**From:** Sarah Burrow <Sarah.Burrow@arun.gov.uk>  
**Sent:** 13 September 2022 14:02  
**To:** Planning.Responses <Planning.Responses@arun.gov.uk>  
**Cc:** David Easton <David.Easton@arun.gov.uk>  
**Subject:** RE: Planning Consultation on: FP/274/21/OUT

Engineers Comments Regarding Surface Water Drainage and Flood Risk

**Application No:** FP/274/21/OUT

**Site Address:** Bognor Regis Golf Club Downview Road Felpham PO22 8JD

Figure 7-1 - SuDS Location Plan

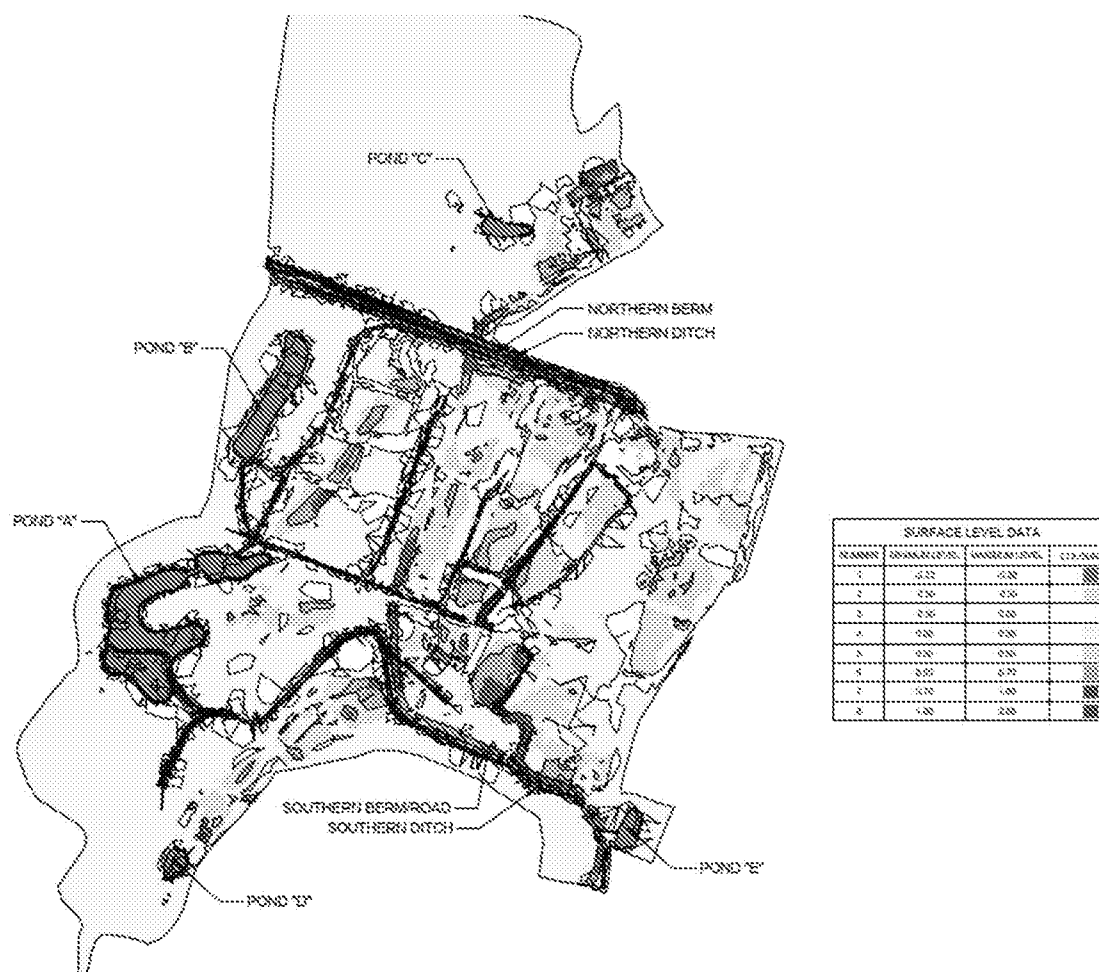
*Surface water drainage features must be located outside of areas at risk from flooding. A minimum of a 3m buffer between top of bank of ordinary watercourses and features which will restrict access for maintenance will be required.*

Figure 6 - Flood Depths and Flowpaths

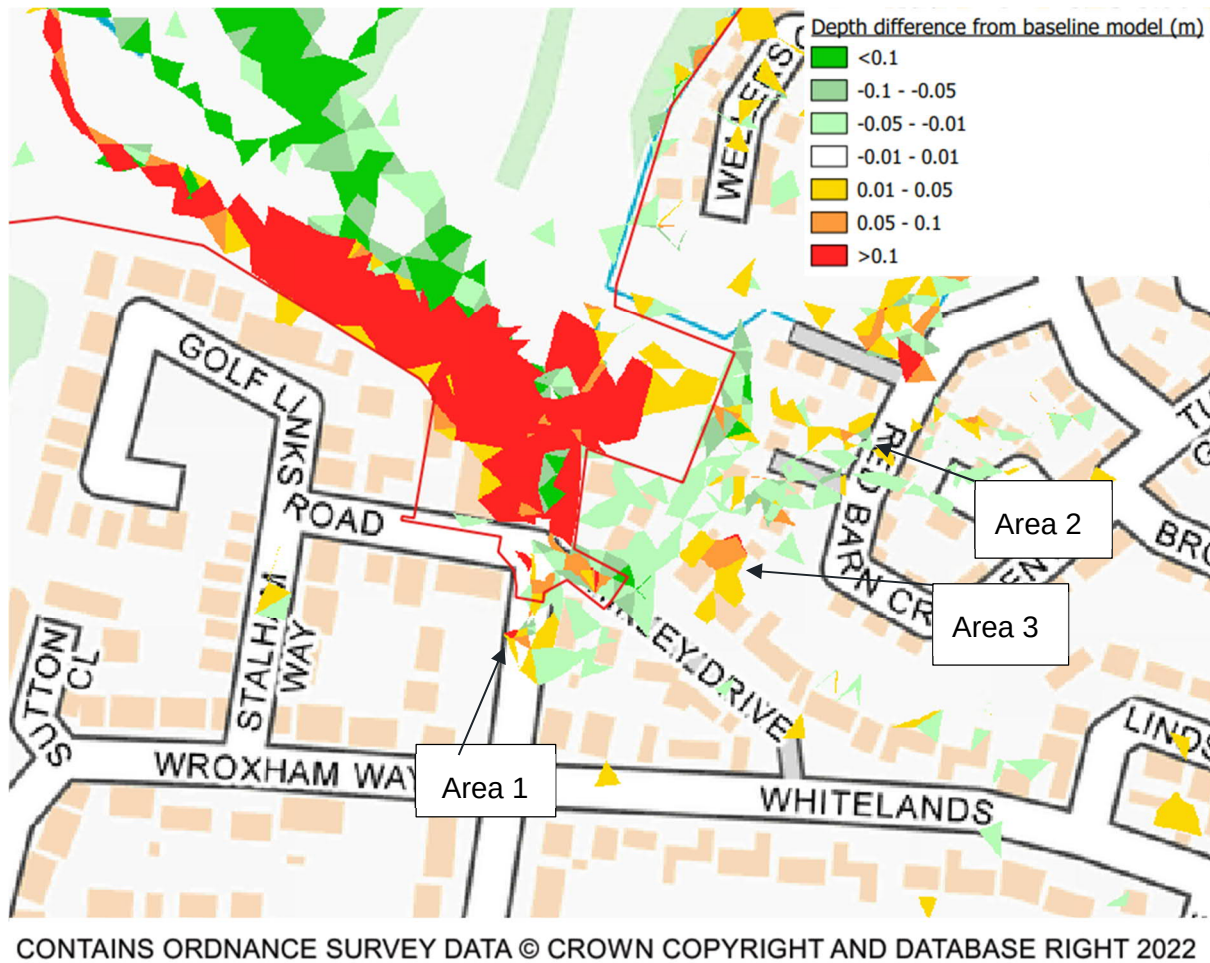
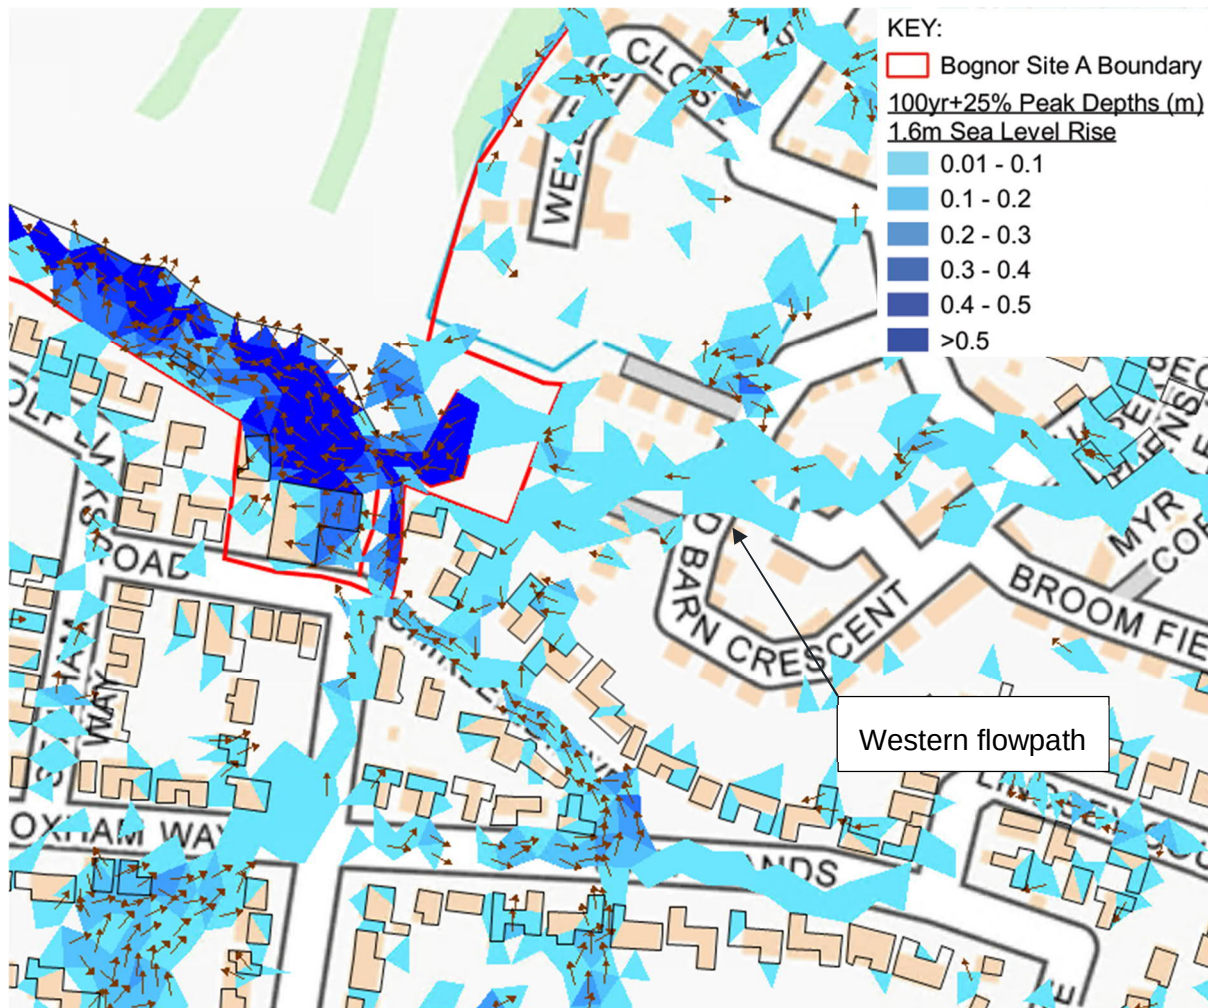
*We note that there is increased flood depth, consistently shown to the south east of the development. We would like to examine depth difference grids and surface water flow volumes in greater detail to establish if an increase in flood risk as a result of development is actually being shown.*
